Application No: **EP/124/20/HH**

Site Address **Little Dormers 23 Upper Drive East Preston BN16 1QN**

Objections/Comments to Planning Application EP/124/20/HH

Drawing Name
Elevations-
Proposed

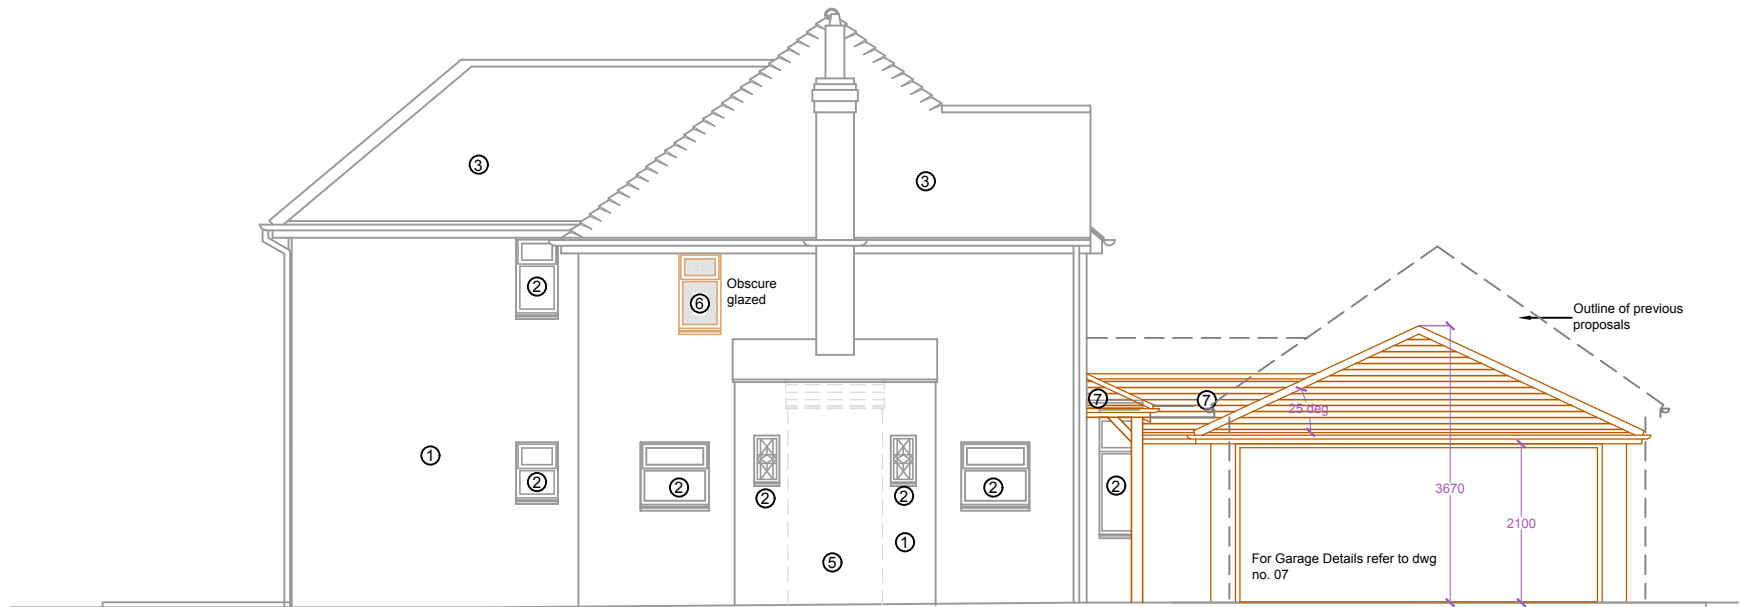
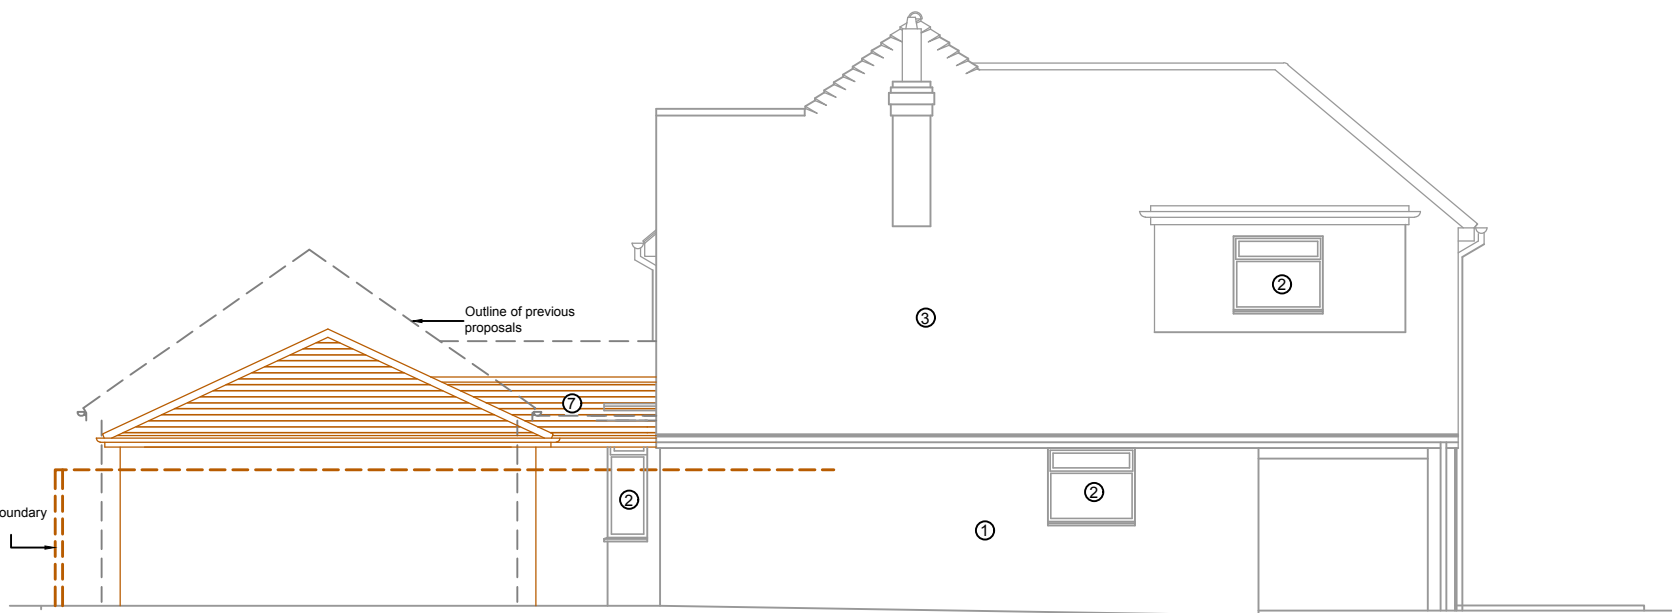
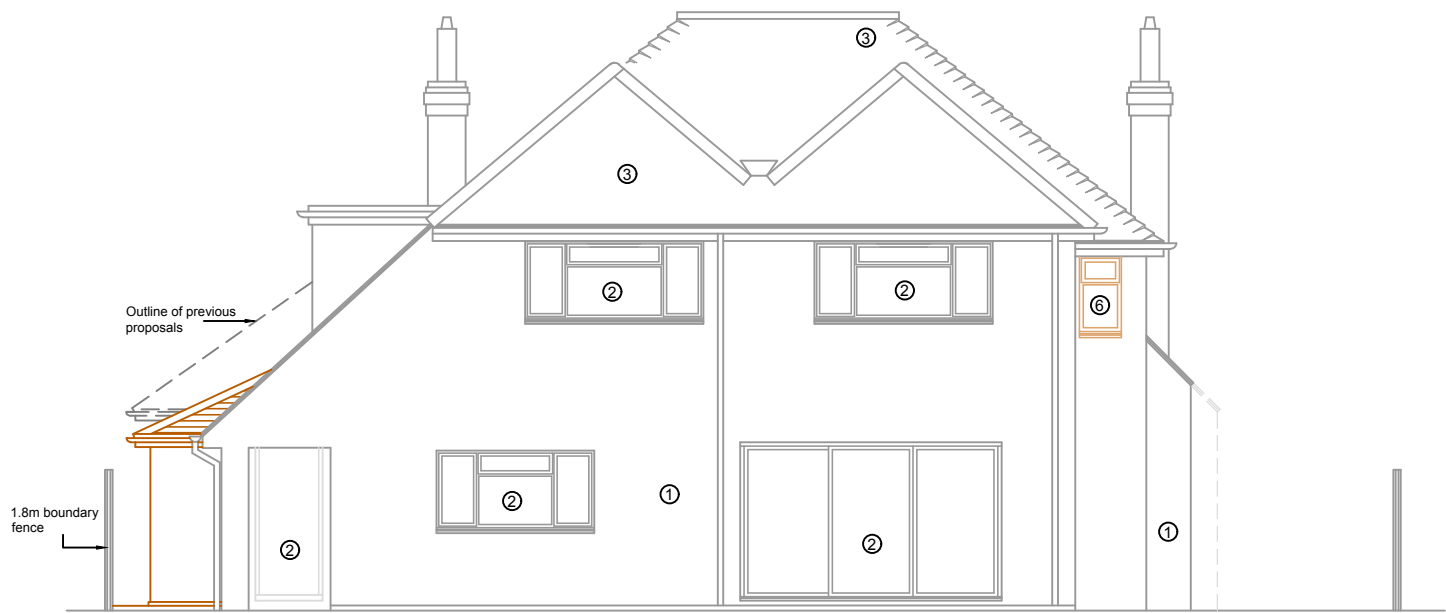
This objection relates to the proposal to insert two new window openings on the first-floor in to the original side-elevation of the building, known as 'Little Dormers', which is south facing.

Sight lines from the two proposed windows on the applicants' application are very significant for neighbours right to privacy in that they have direct overlooking views covering the small, back garden areas and patios (used frequently for peaceful enjoyment), and into the main living areas. In particular, the two large patio windows of the lounge and dining rooms of the bungalow at 59 Manor Road. *(The narrowness of the gardens and overlooking issues can easily be seen from a site visit to 59 Manor Road, particularly as the block plan does not appear to be an accurate depiction of widths)* This introduction of window openings on the side first-floor level is clearly against paragraph 13.4.3 of the Arun Local Plan which states that alterations should "Not lead to overlooking, overpowering, or over shadowing of neighbouring properties".

It is evident from the revised plans now resubmitted by the applicants' that they have not taken up this compromise, but have now labelled only one of the proposed new window openings as obscured glass, without even indicating that this should be a non-opening window. This seems very insensitive to the number 59 Property, given that there are two other windows and the most westerly proposed opening is the one closer and has the much more intrusive, and angled view into the garden, lounge, and dining areas. This window is also immediately above the well-used 'sunny' patio area, being the only place where the small, north-facing rear garden can consistently follow the sun without being in the shadow of its own building. However, although totally unsatisfactory, this very limited action by the applicants, if not wholesome, tacitly admits to the problem of privacy for neighbouring properties, which the previous application pointedly ignored.

We would not be happy with obscured windows, fixed non-opening, that did not relate to landings or bathroom areas as these can easily be changed at a later date; we understand many Council Planning Authorities share this practicable view. If this was to be the case, we would expect it be conditional that all three windows on the south side have to conform. However, we are not in favour of this solution as it would create an array of three unwelcome, window openings on the upper-floor south side-elevation.

Floor Plans and Roof Plan -
Proposed

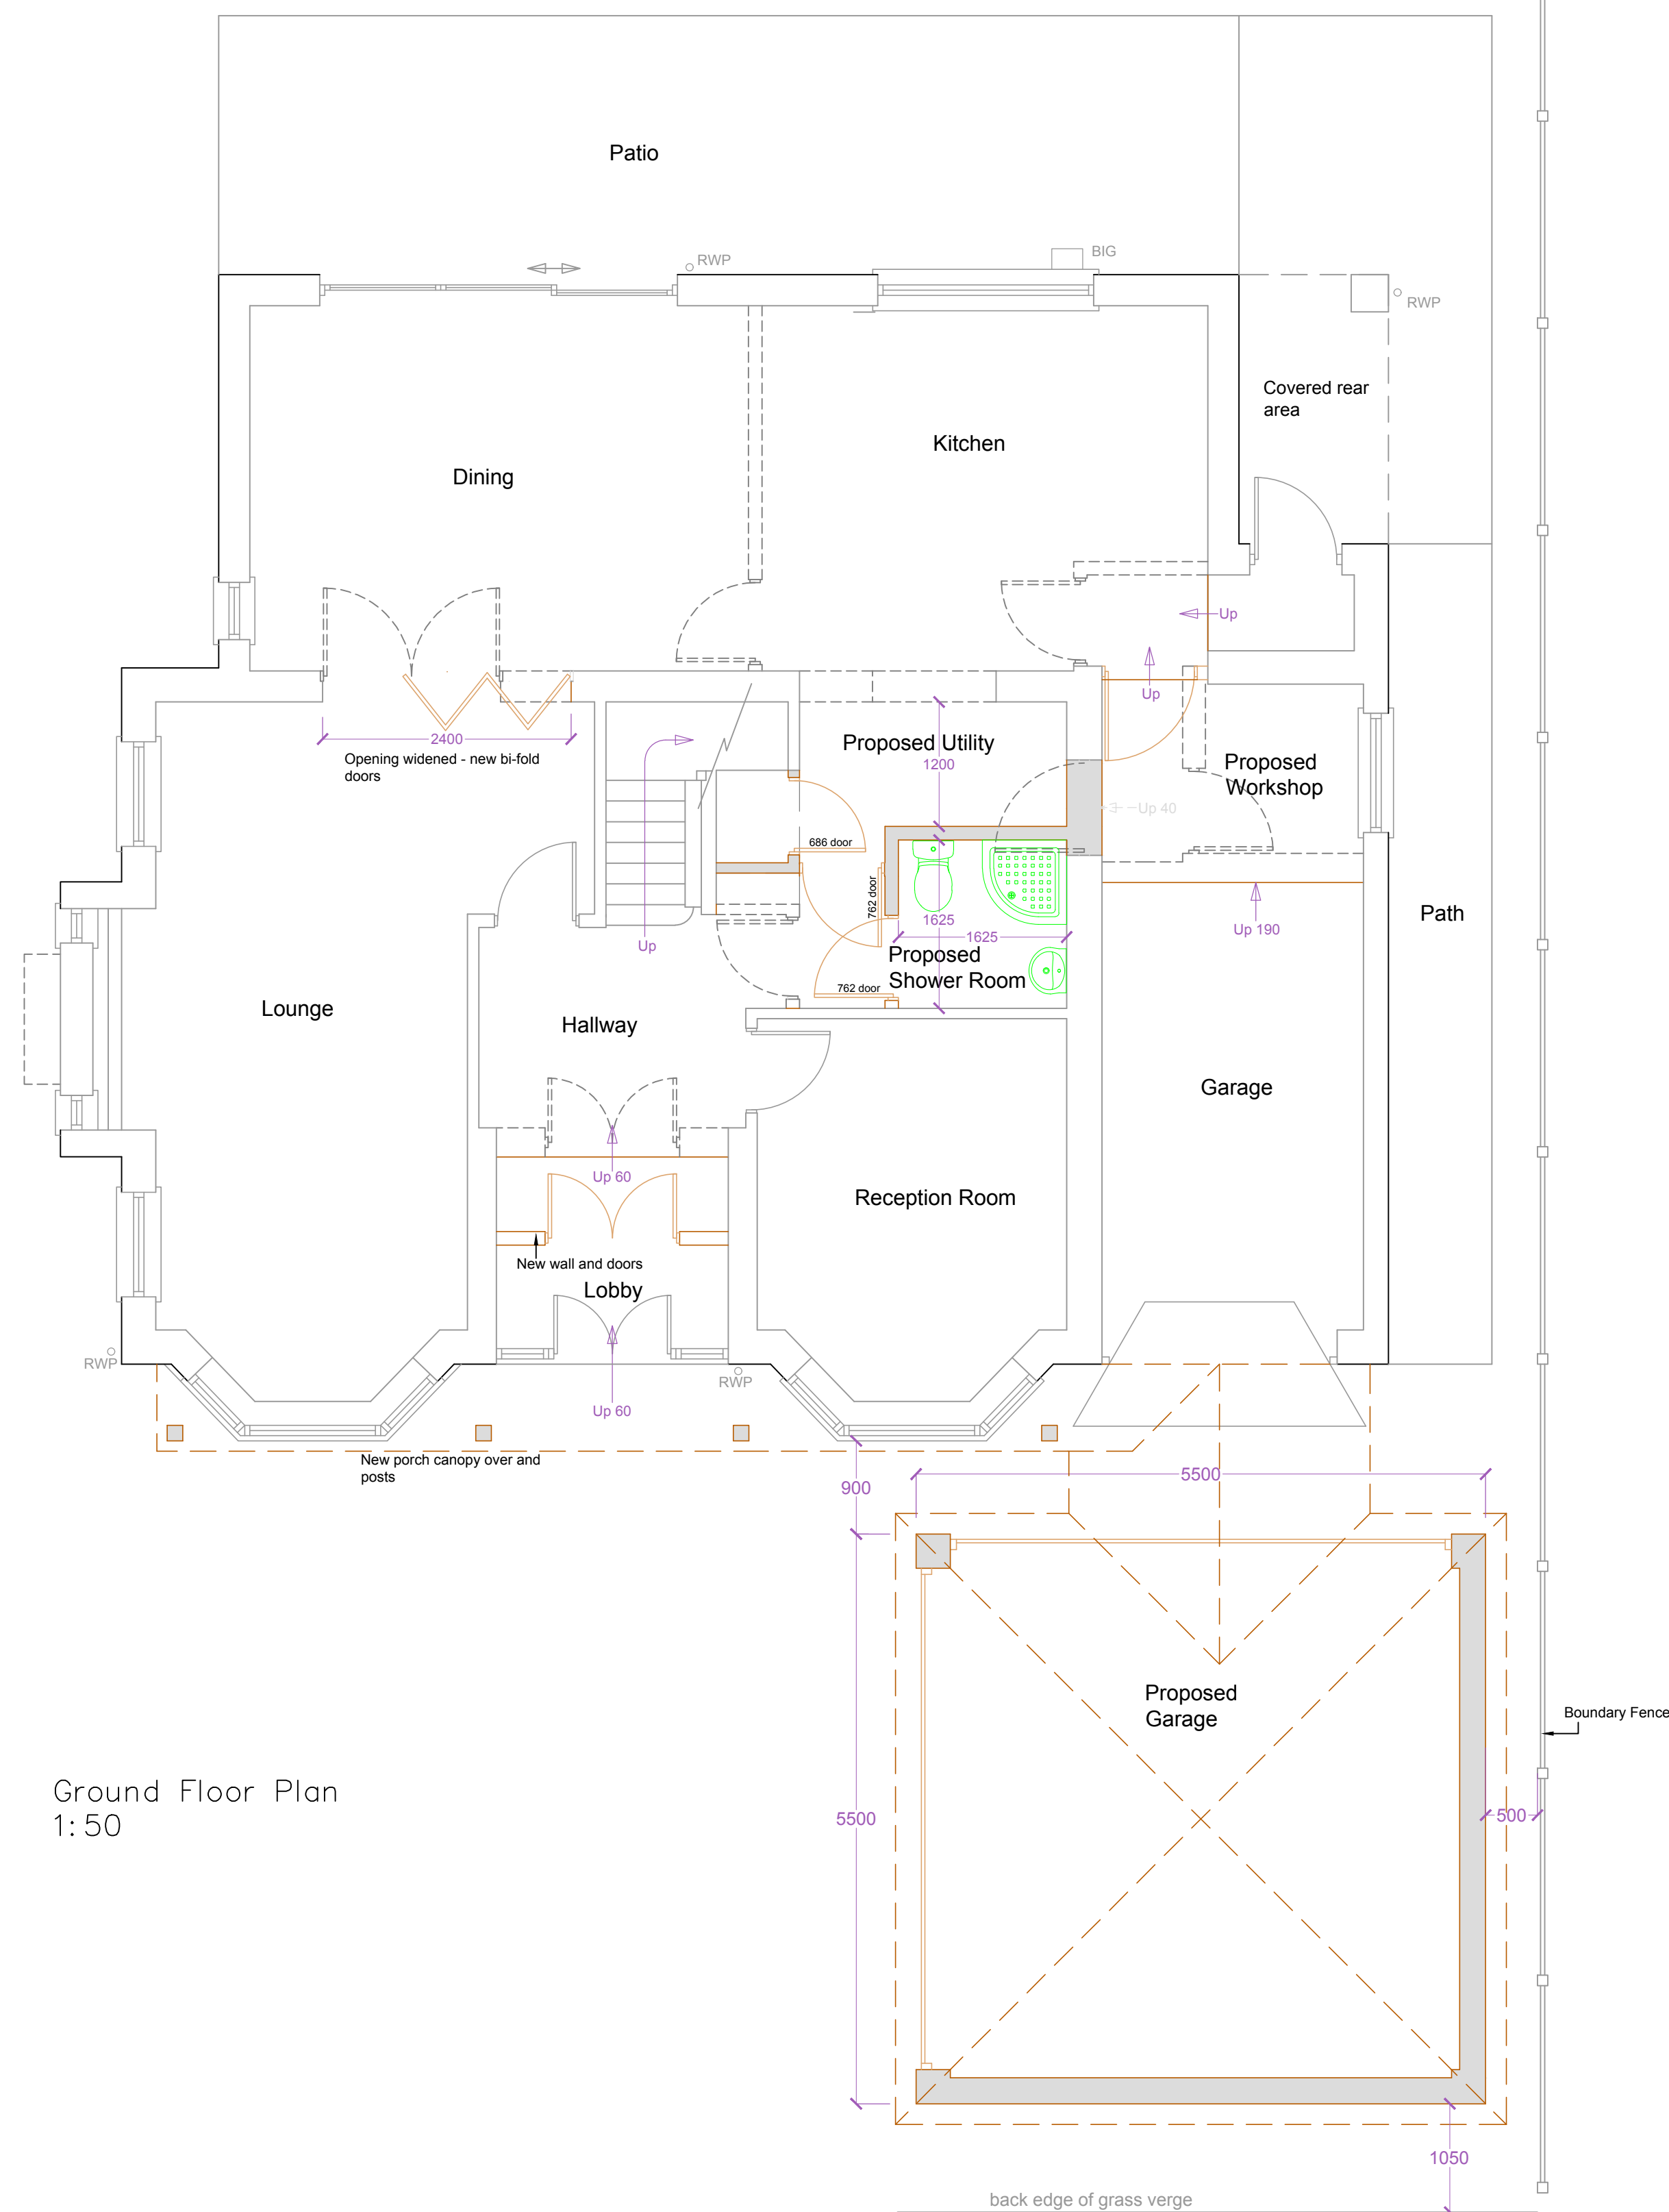
The plans show that this new windows proposal is part of the applicants' wish to reorganise the upstairs layout of the already existing four bedrooms. We have absolutely no desire to stop our new neighbours rearranging the internal upper-floor layout to suit themselves and wish them well. However, removing the privacy amenity for other residents from the side elevation should not be sacrificed for any internal design choice, particularly when other options such as Velux windows or light tubes for the roof itself are readily available for what is a secondary bedroom in a house of four existing bedrooms.

Garage Plans and Elevations -
Proposed

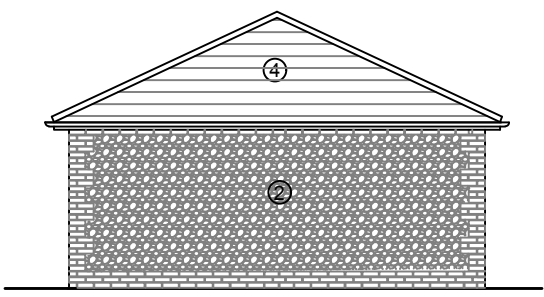
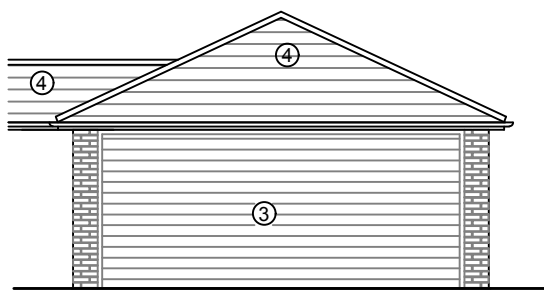
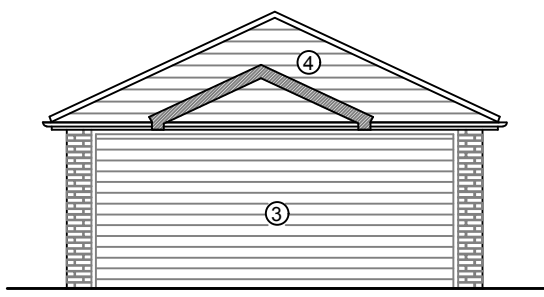
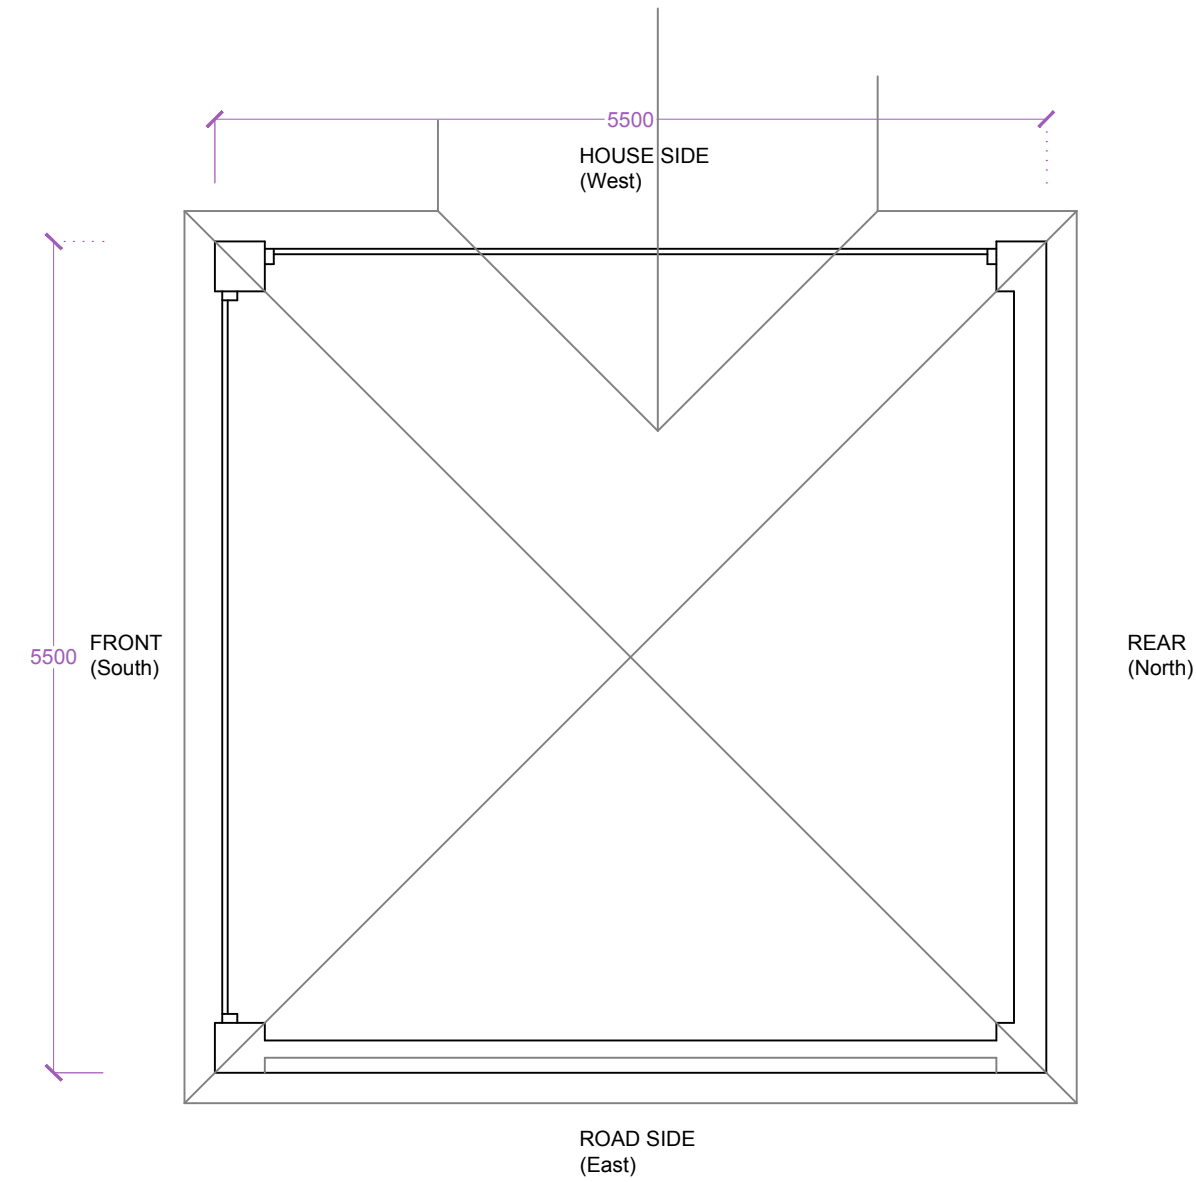
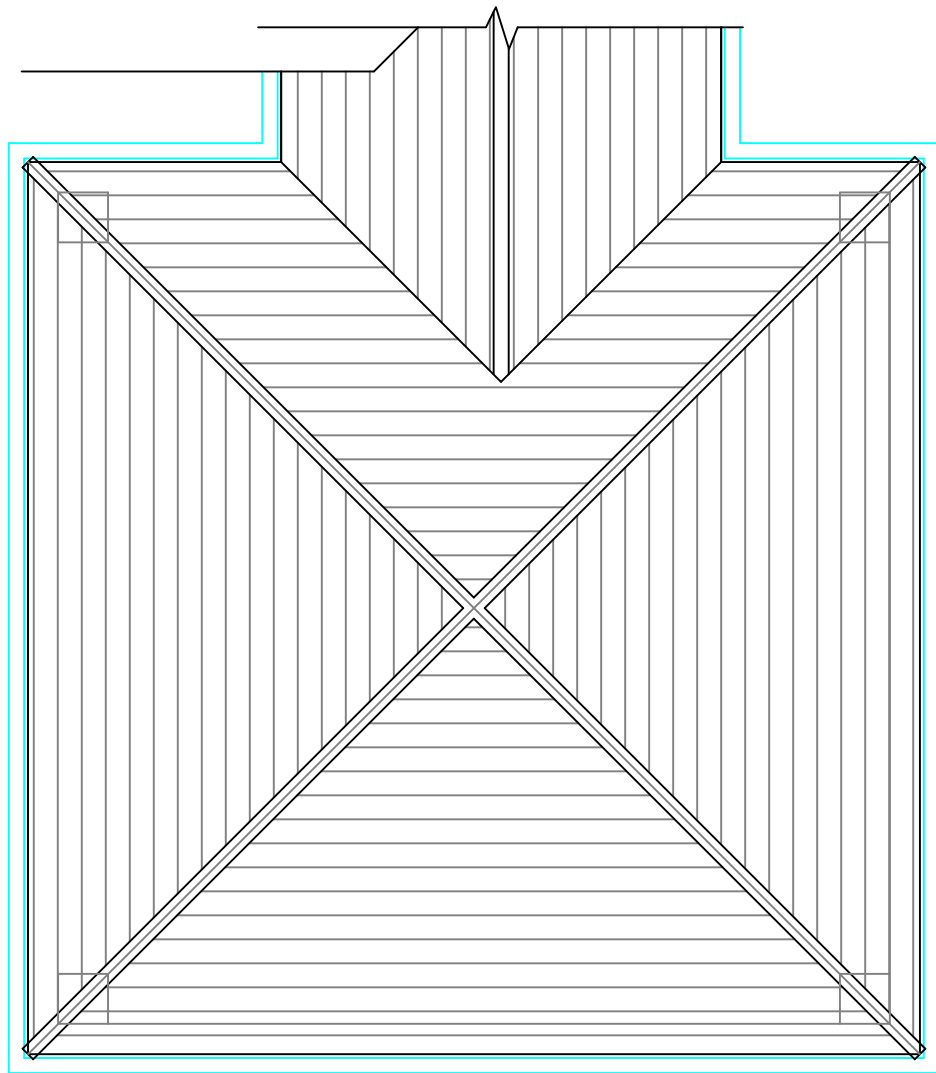
- a) The proposed structure is large, overbearing, and beyond a visual and natural building line that all residences in the road follow to achieve an orderly pattern on the road and neighbourhood. This pattern is essential (Arun Local Plan, para 13.4.5) and can be easily observed on many identical estate patterns, particularly where the front gardens are small, as in this instance.

- c) The density and siting of the proposed construction on the plot, stretching to the edge of the road/narrow verge in the front garden, do not respect the surroundings of the property (Arun Local Plan 13.4.4). In particular, the vision of the property from pedestrians and vehicles entering the narrow road from the South, who will at best be faced with a view of garage doors or worse, views of the inside of the garage/workshop with its attendant contents. The view coming into the road from the North only presents itself as a high, out of place, brick wall running down a front garden to the road. Therefore, the proposed structure does not represent a positive addition to the established special character and pattern of the place as required by Arun Planning Policy (D DM4, item e) and actually harms the character of the road.

d) The siting of the structure is detrimental to the neighbouring property to the North of the Plot. It creates an overpowering and overshadowing effect on the neighbour's front garden and their one-and-a half-storey dwelling. This is shown to be unacceptable by the Arun Local Plan D DM4, item c.

e) The applicants already have an integral garage and this proposal would not add to off-road parking spaces as the layout of the proposed entrance would mean the spaces in front of the proposed double garage are required for access rather than parking. This may also mean that the purpose of the garage is more intended for workshop purposes rather than garaging. If this was the case the introduction of the noise factor in a front garden so close to the road and other nearby properties could be a significant planning factor and we would expect that this will be considered by the planners as having a negative effect on the road.
